**WEST SUSSEX COUNTY COUNCIL
INFRASTRUCTURE CONSULTATION**

SUBJECT: BR/83/10-Change of use from offices to two flats.

9, Lennox Street, Bognor Regis, West Sussex, PO21 1LZ

FIRST FLOOR
proposed

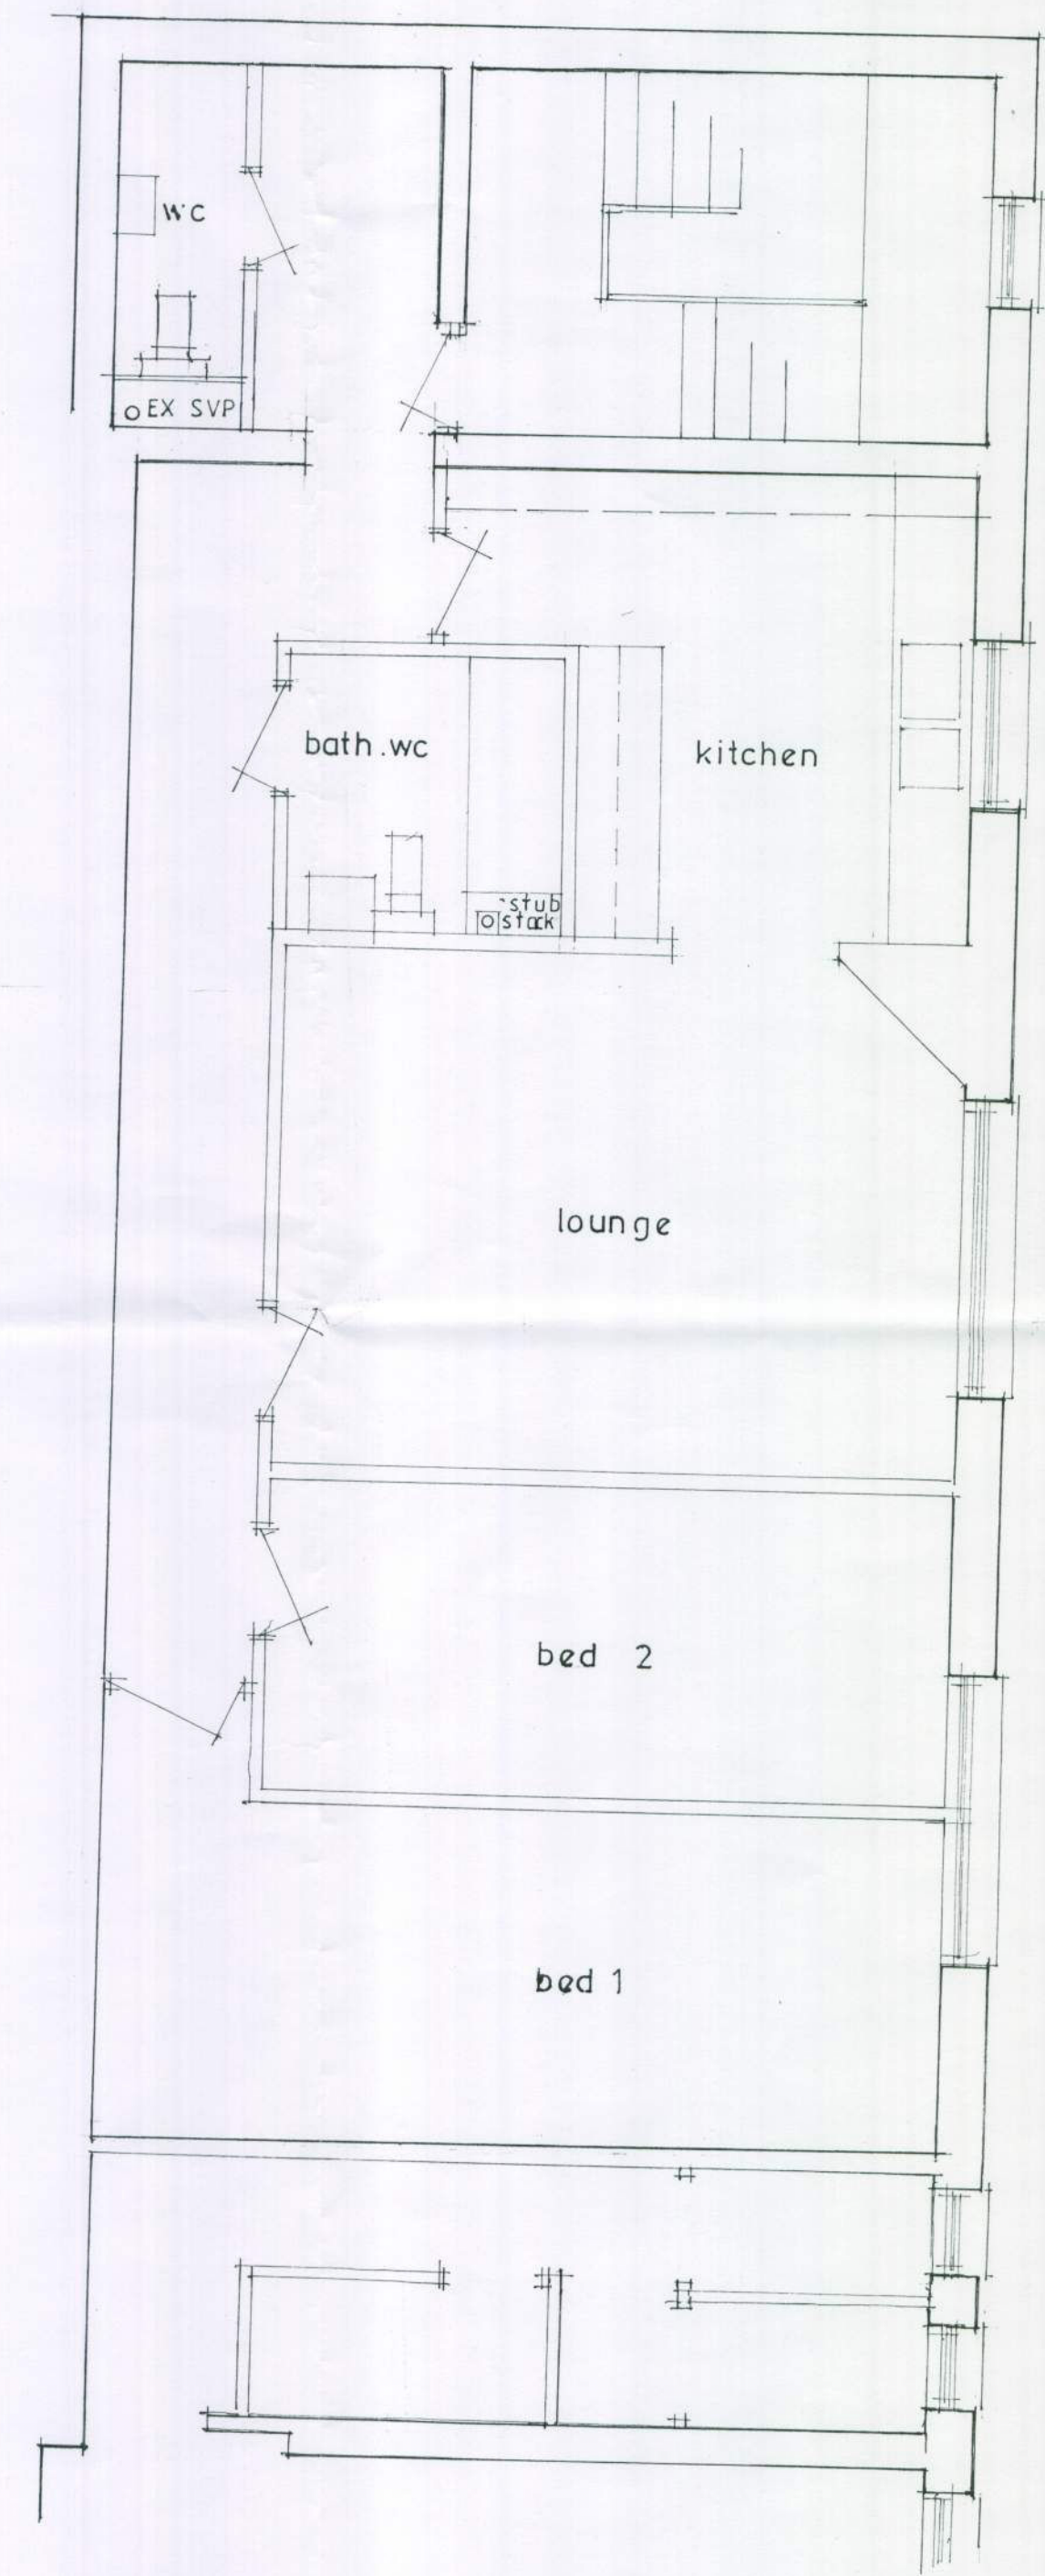
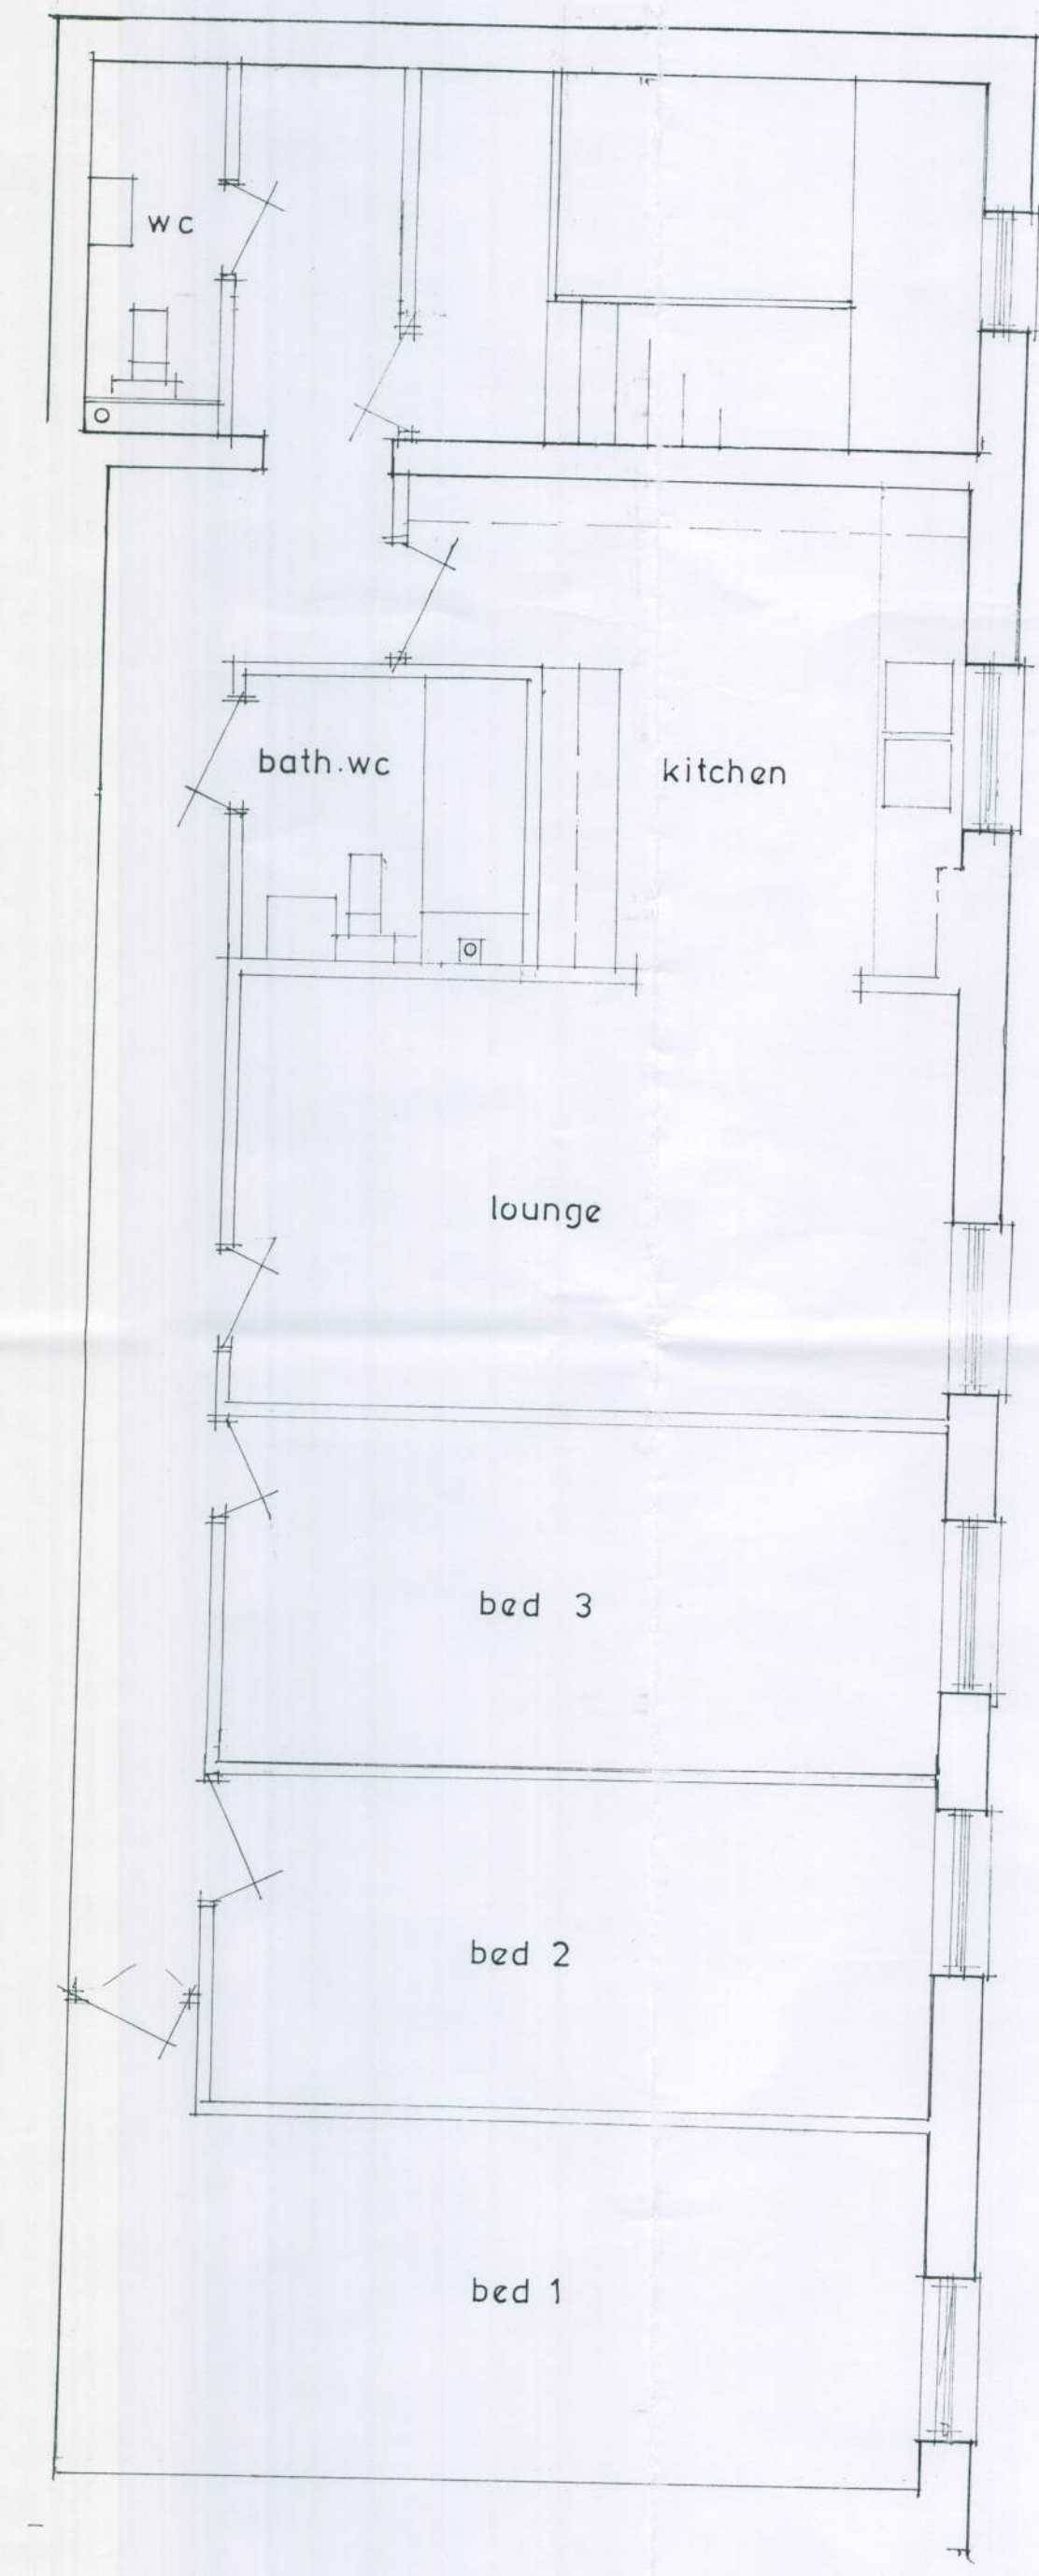
A nil car parking provision is proposed for the new flats. Under the WSCC Car Parking Standards, a maximum of four car parking spaces may be provided for the proposed flats. Consequently, as the maximum is not being exceeded no concerns would be raised. Whilst on-street car parking is limited in the immediate vicinity, the previous use of the site would have generated a similar parking demand. On that basis I would not consider that highway safety would be detrimentally affected through the proposed nil car parking provision. The Planning Authority may wish to consider the potential impacts of this development on on-street car parking.

Cycle parking should be included however; this must be secure, covered and be capable of storing at least one cycle per bedroom of the proposed dwelling. The actual details of the cycle parking facilities should be submitted to and approved by the Local Planning Authority (LPA). To accommodate cycle parking it would be recommended that any cycle store should have minimum dimensions of 2m x 1m.

If the LPA are minded to approve this application, a condition securing cycle parking should be included.
